Application Reference: 2026/0315

Site Address: 2 Chapel Lane, Billingley, Barnsley, S72 0HZ

Introduction: This application seeks full planning permission for the proposed removal of existing conservatory and erection of rear single storey sunroom extension with stepped terrace.

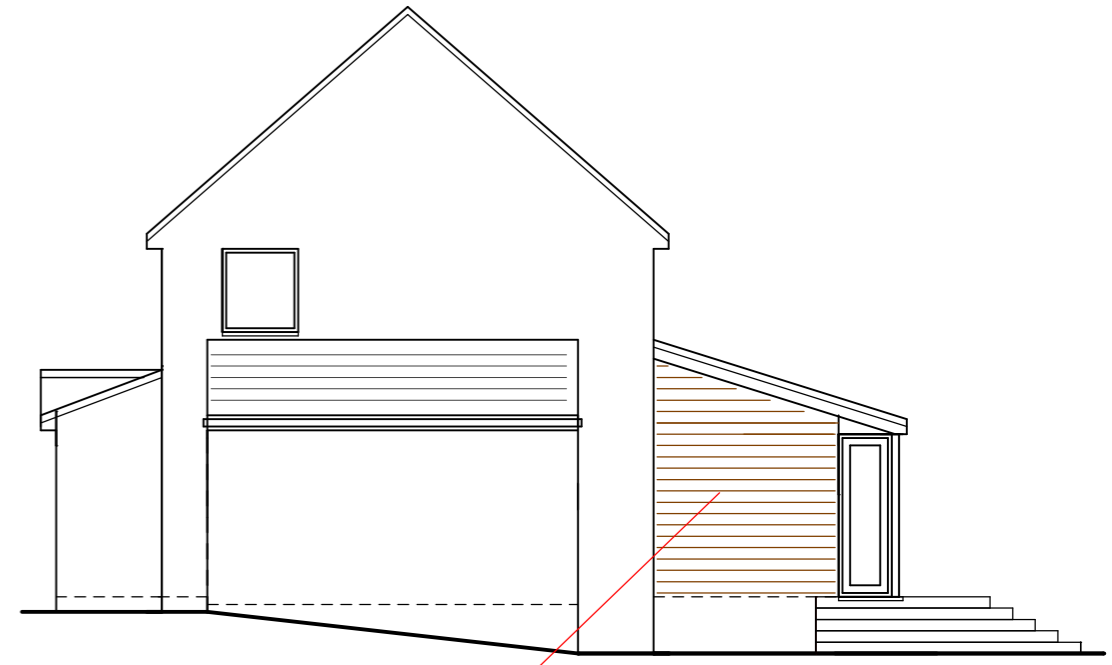
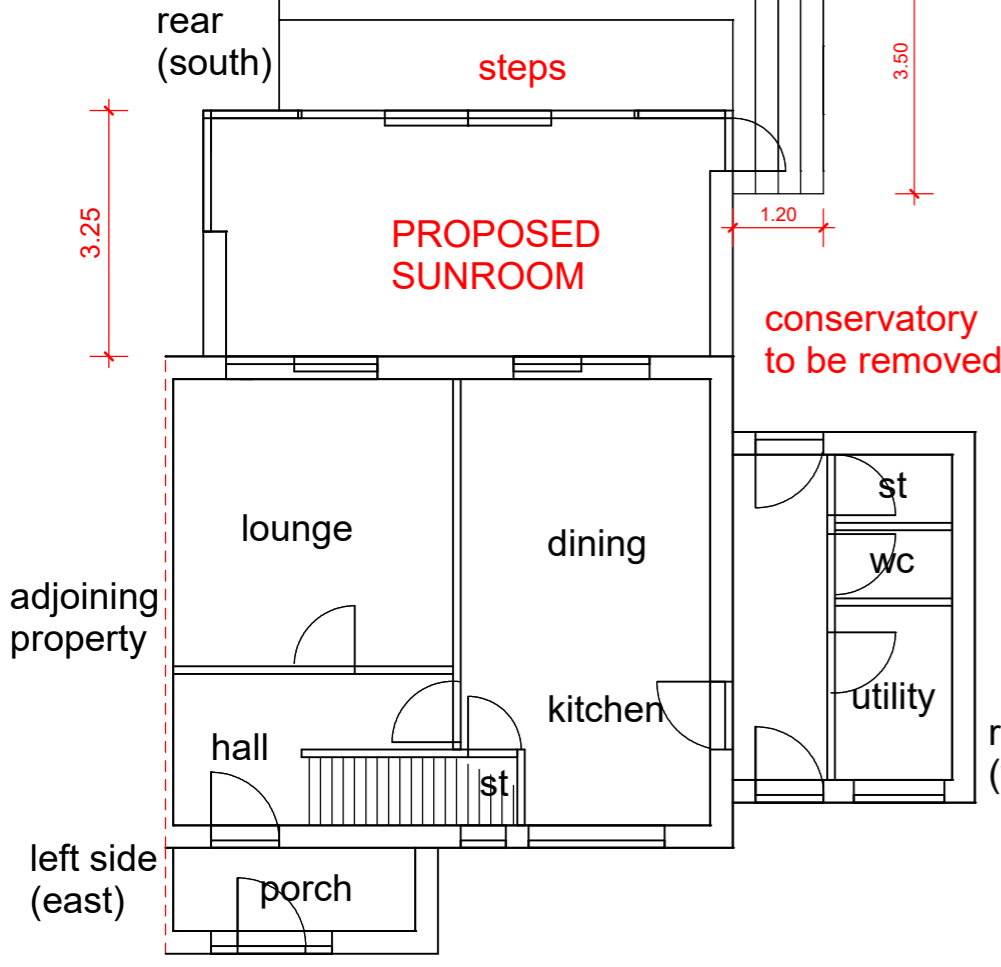
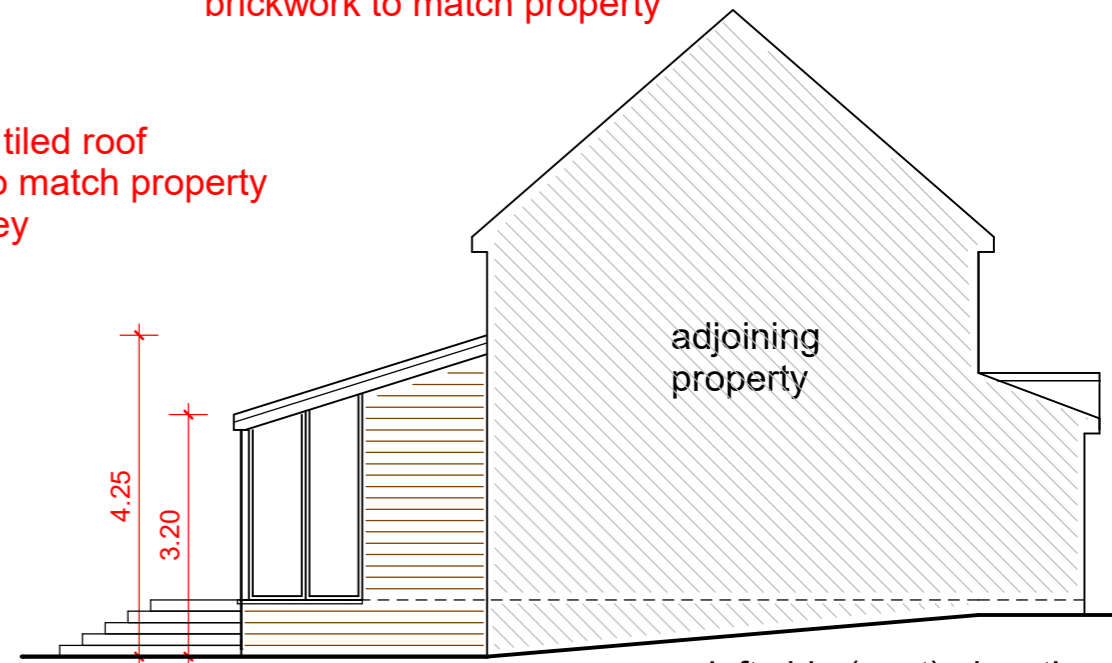
Only the attached neighbouring dwelling would be impacted by the proposal. Whilst there has been no comments or objections to the proposal, there is potential possible harm to the amenity of the neighbouring dwelling. Based upon a estimated 45-Degree angle form the centre of the neighbouring dwelling's rear elevation French doors; the line of the 45-degree angle would intersect the corner of the proposed sunroom.

In mitigation of this breach, firstly the breach is quite small, and any amendment to the proposal may be difficult to implement and would have minimal benefit for the neighbouring dwelling. Secondly, the extension is just 0.25m (25cm) in projection to long to otherwise be allowed through permitted development. Finally, whilst there is not a current high boundary treatment between the dwellings, subject to any potential consent from the Conservation team, a higher rear boundary treatment of up to 2m high, may be erected by either current or future occupants of either dwelling, which would significantly reduce any impact caused by the proposed extension.

With a modest impact on residential amenity, which if required by the applicant or neighbouring dwelling could be reduced to little or no impact with the introduction of a higher boundary treatment the proposal would be considered in accordance with Local Policy GD1. This carries moderate weight in favour of the proposal.

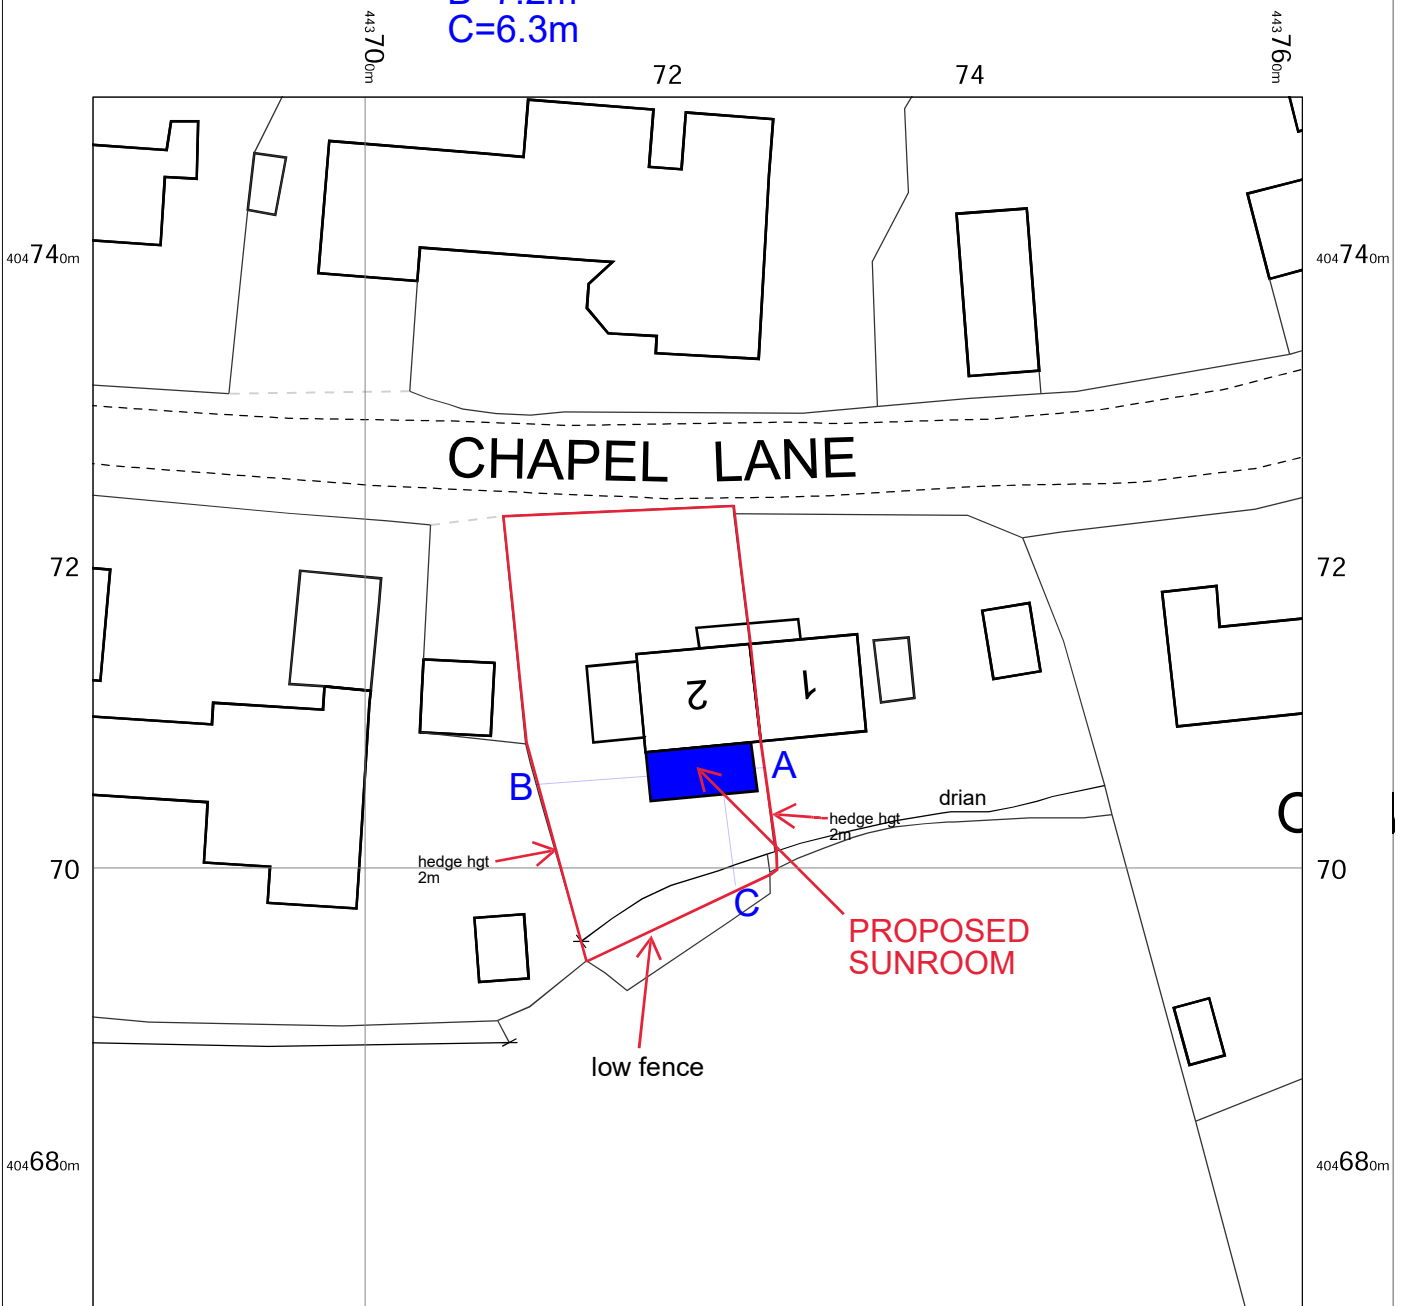
- Revised plans showing the existing garage and shed were requested to correctly calculate the Green Belt calculations.
